From: Liz Rogers [REDACTED]
Sent: 27 August 2015 14:38
To: Planning.Responses
Subject: RE: Planning Consultation on: BN/29/15/PL

APP NO: BN/29/15/PL

Site Address: Land at Barnhan Court Barnham

Description of Works: Solar park including the erection of solar arrays, inverters, transformers, equipment security fencing, internal tracks, ancillary equipment & ecological mitigation. This is Departure from the Development Plan.

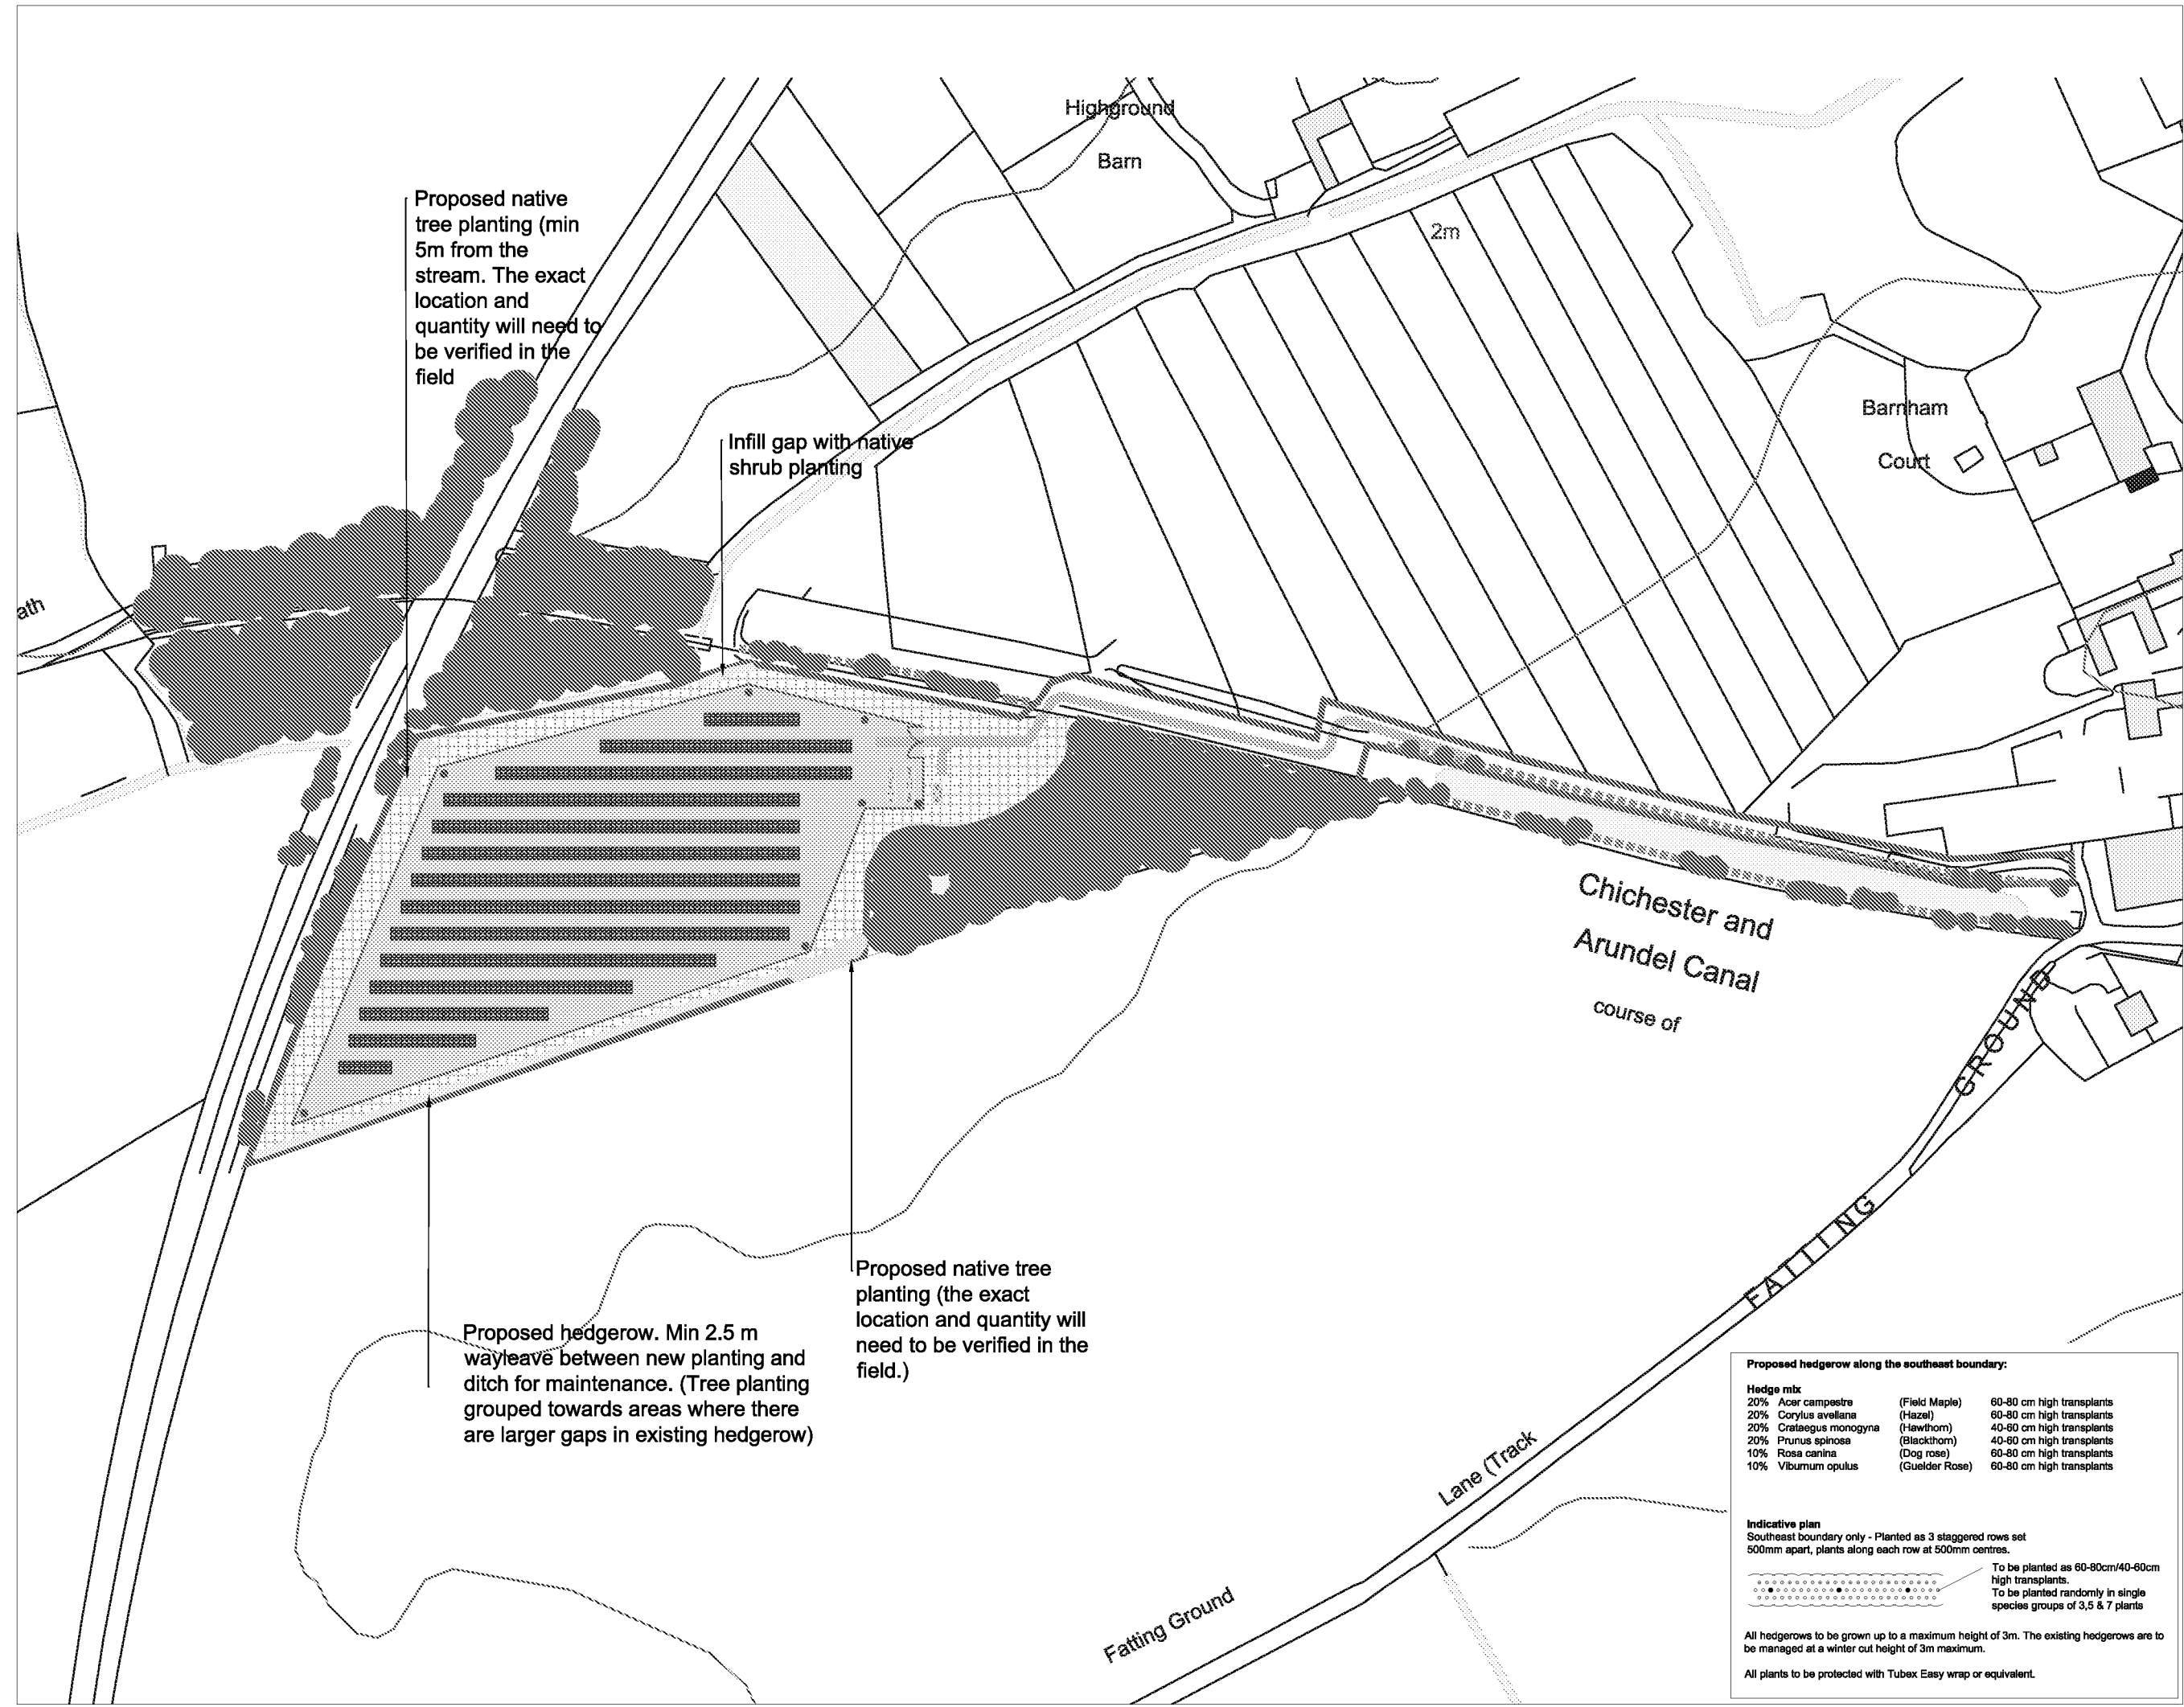
The badgers and other mammals should have unrestricted access to the solar farm field and should be able to forage in the field for their usual food sources; we are pleased to see the incorporation of mammal gates within the boundary fencing.
